Application for Planning Permission for Works or Extension to a Dwelling

Development: Proposed construction of a single-storey rear and side (wrap-around) extension to the existing detached dwellinghouse, with a flat roof and external timber cladding.
Location: 40 Greencourt Drive Bersted PO21 5EU

ADDRESS	
40 Greencourt Dr, Bognor Regis PO21 5EU, UK	
TITLE	
ELEVATIONS	
PROJECT STATUS	
PLANNING DRAWINGS	
DATE	JAN 2026
REVISION	A
SCALE	As Indicate @A1
SHEET No.	WD003
REFERENCE	0010/20/FA
DRAWN BY

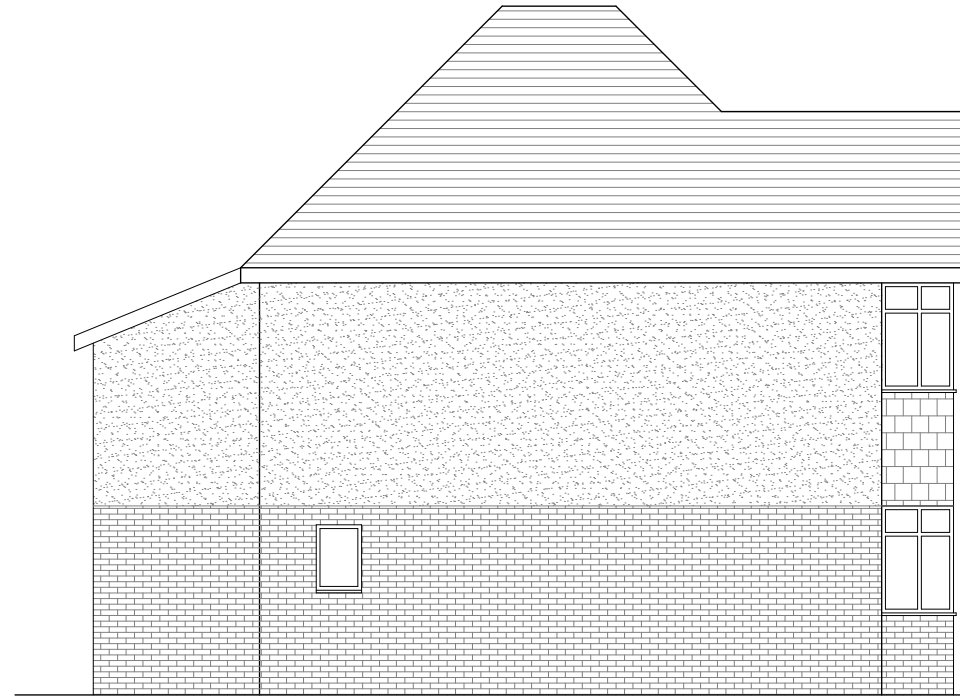
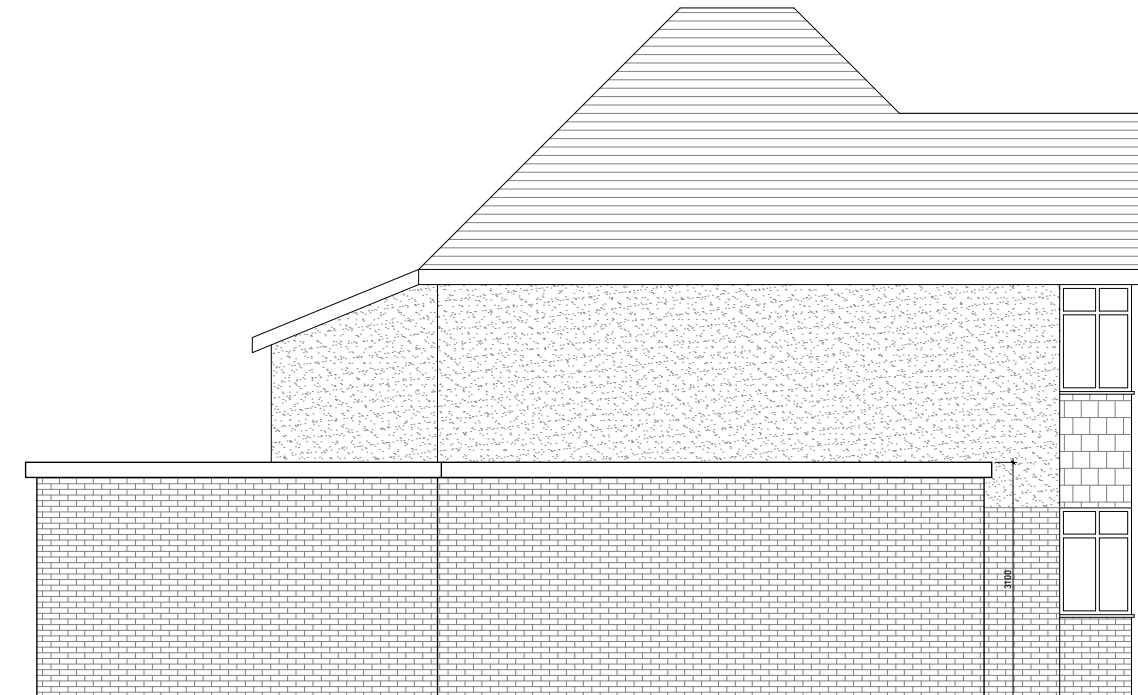
Elevations

Please submit electronic plans in pdf format clearly labelled existing and proposed front elevations at a scale of 1:50 or 1:100. Further details can be found in the Validation Requirements List.

Site Plan - 40 Greencourt Drive Bognor Regis

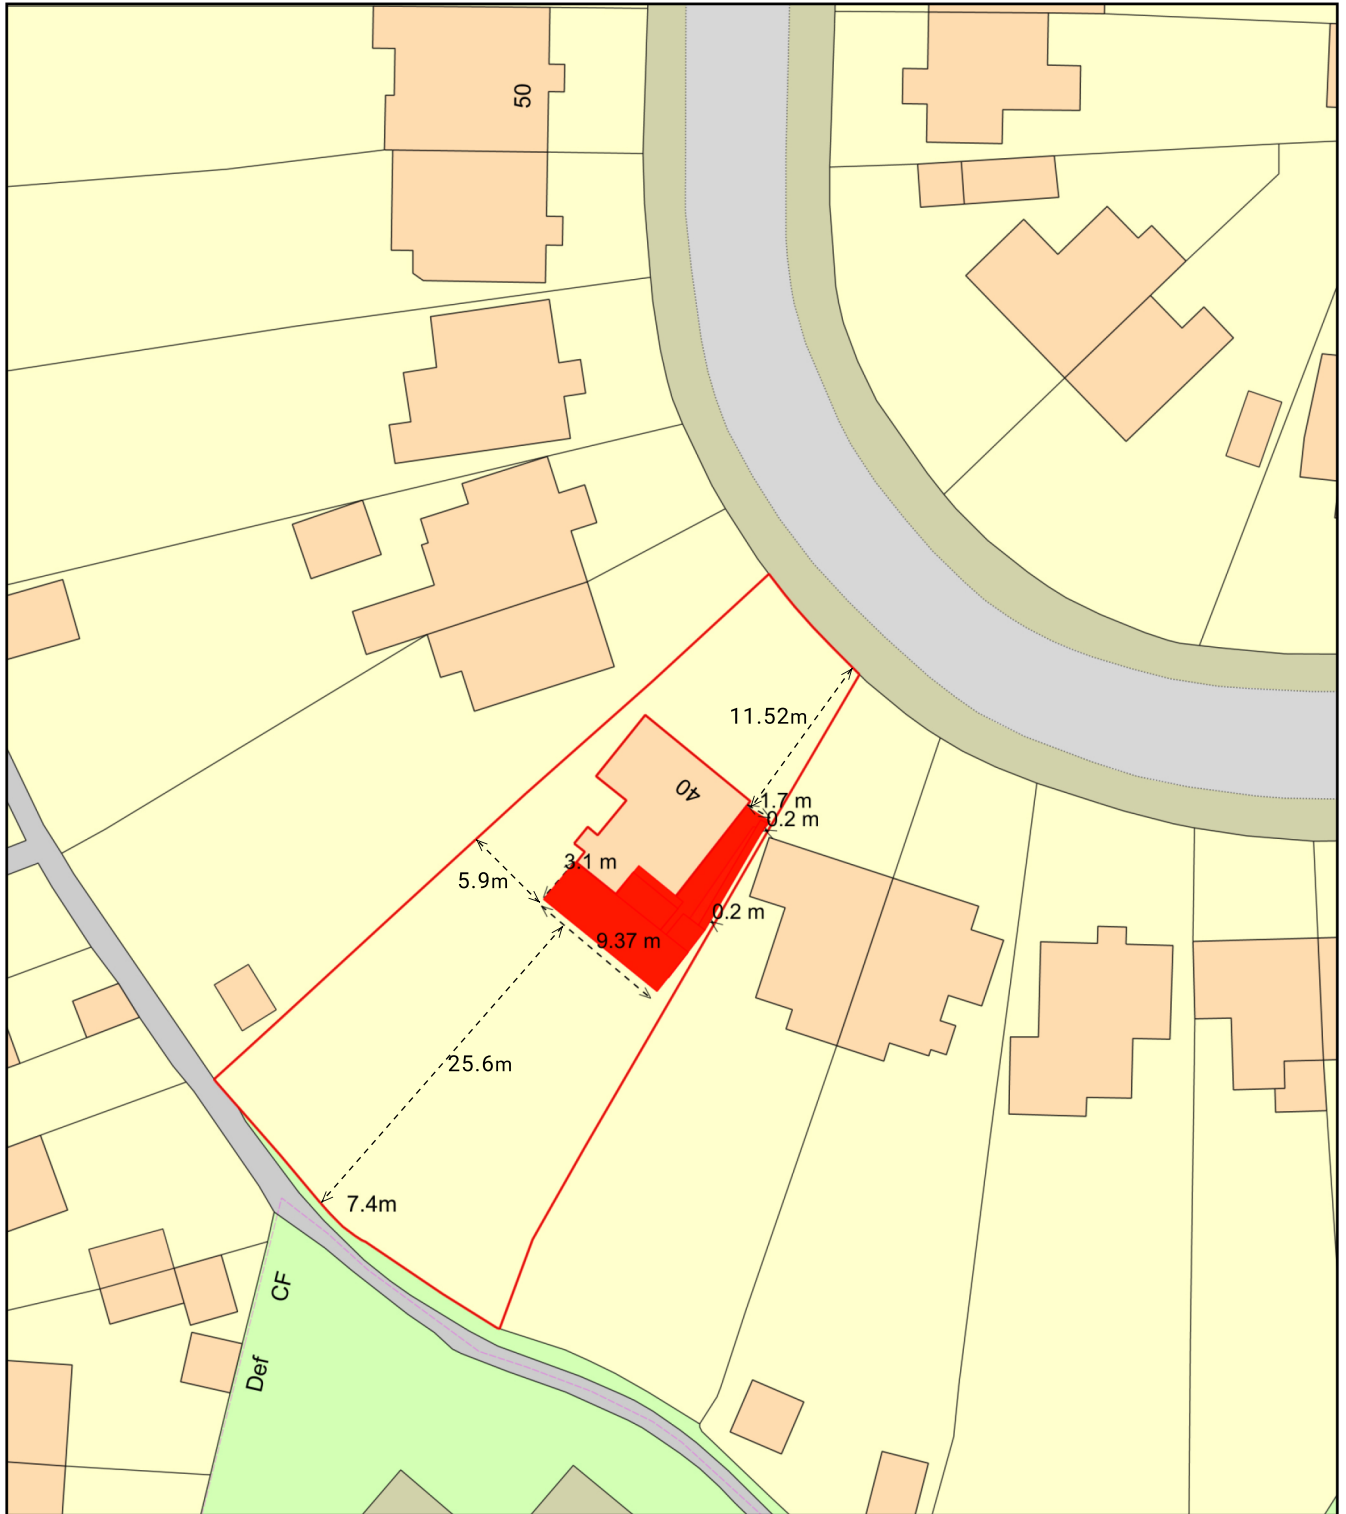
Block Plan

You are required to have dimensions from the proposed extension(s) to all site boundaries. Please amend.
